Longfield Solar Farm

Chelmsford City Council

Unique reference: LOSF - 002

ExQ1 - Responses to Written Questions

**FIGURE NUMBER**

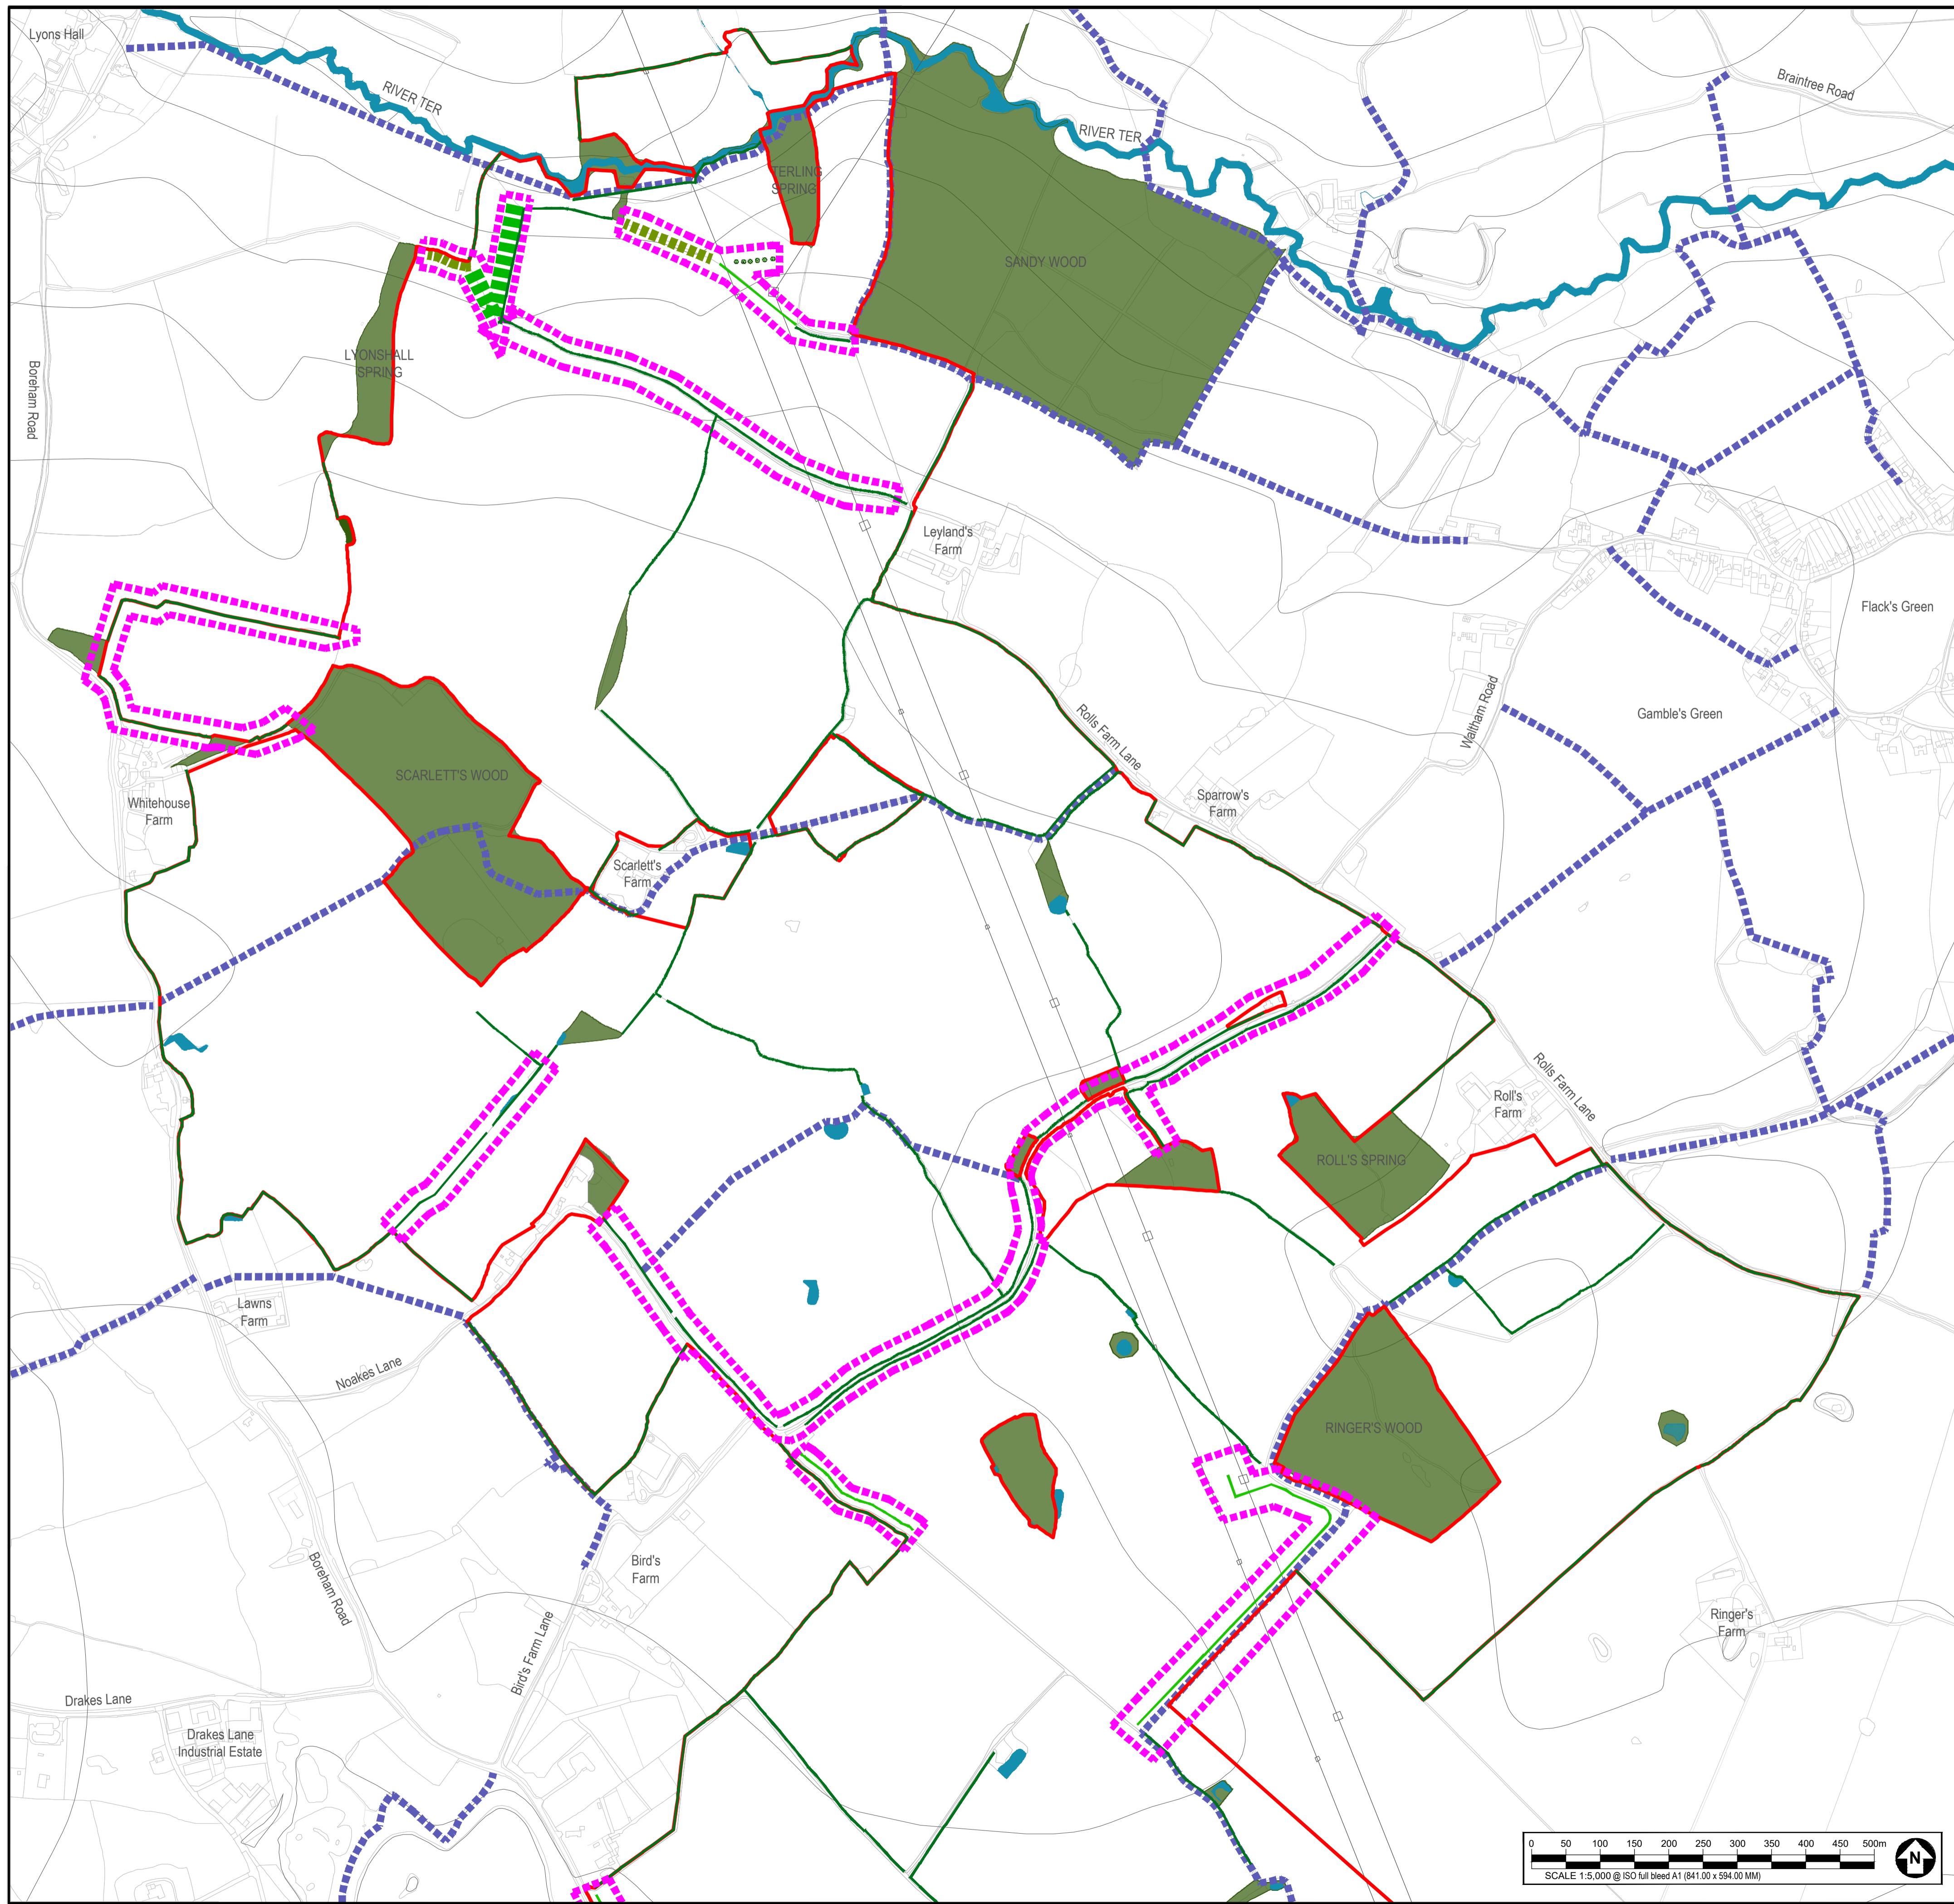
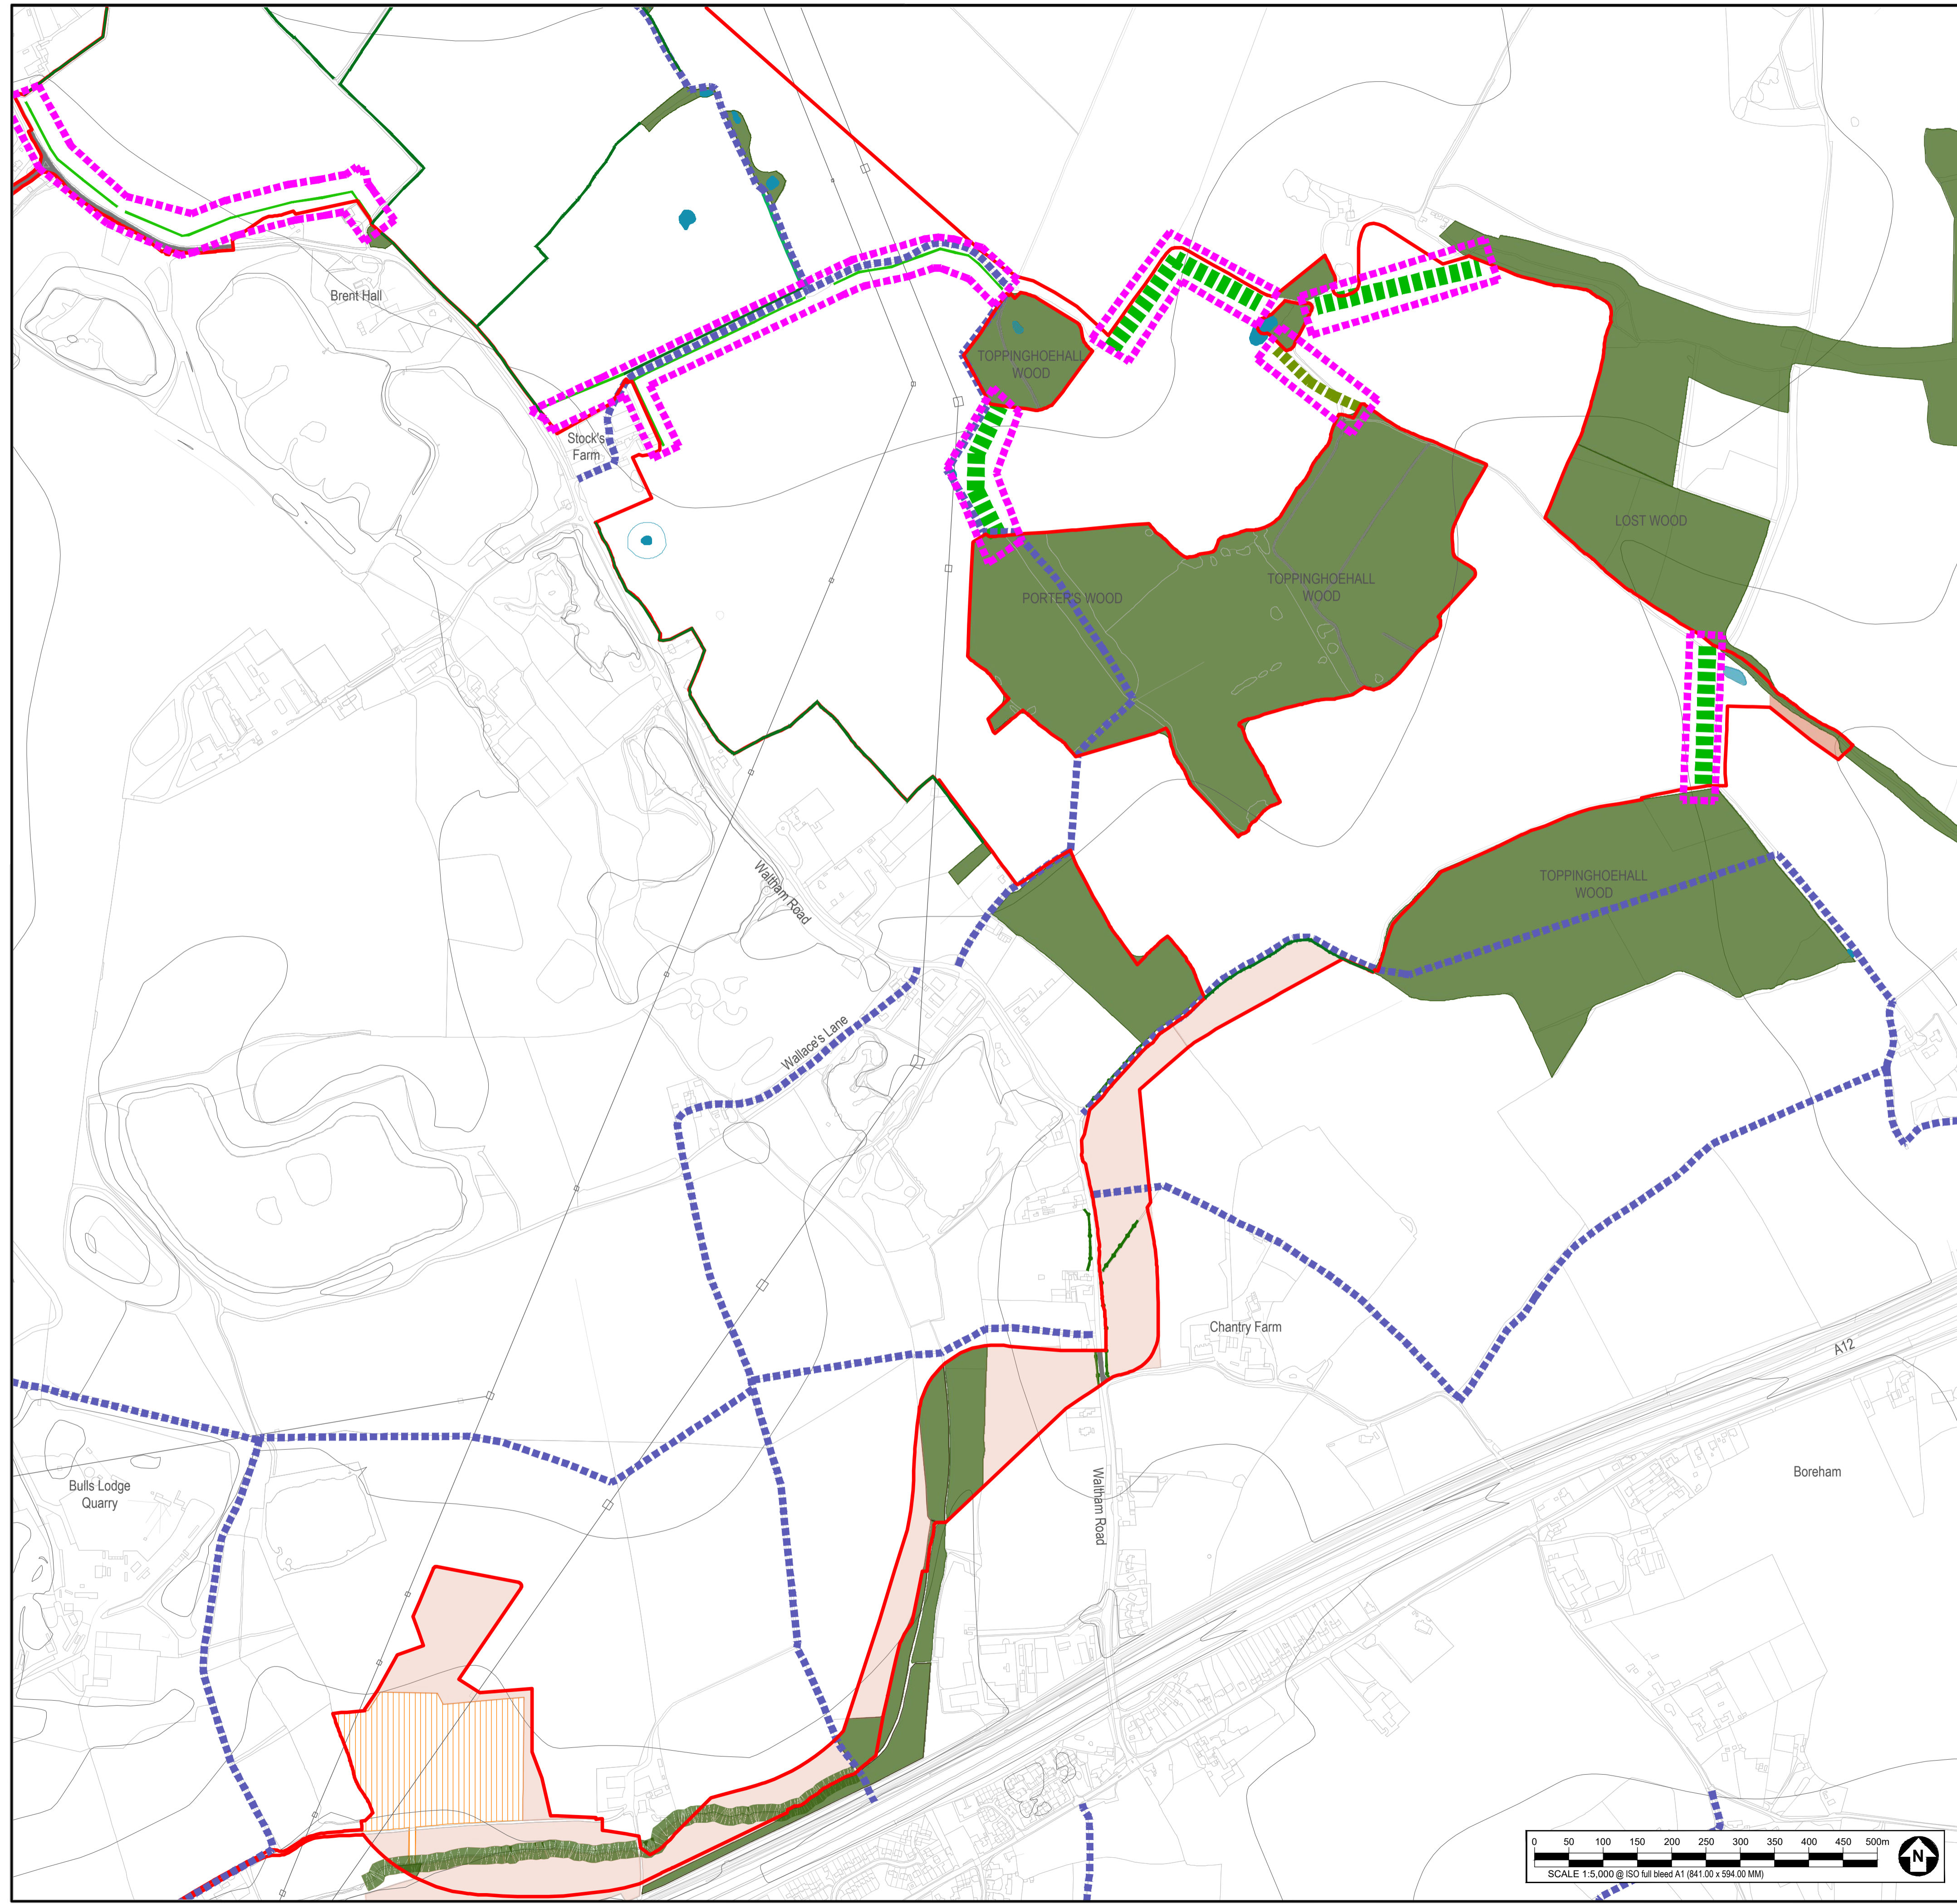
1.8.3	Host Authorities	Could the relevant Host Authorities confirm whether they are in agreement with the proposed landscaping mitigation measures and (as relevant) monitoring proposals, as set out in the Outline Landscape Masterplan [APP-179], the oCEMP [APP-214], oOEMP [APP-215] and the oLEMP[APP-217]?	<p>CCC confirm it is content in principle subject further to further discussion on the following three items:</p> <ol style="list-style-type: none"> 1. Approach to vegetation removal / management on Noakes Farm Lane (protected lane) 2. Screening of view from Viewpoint 45 (Essex Way north of River Ter) 3. Advance planting of PDA 1 scrub area
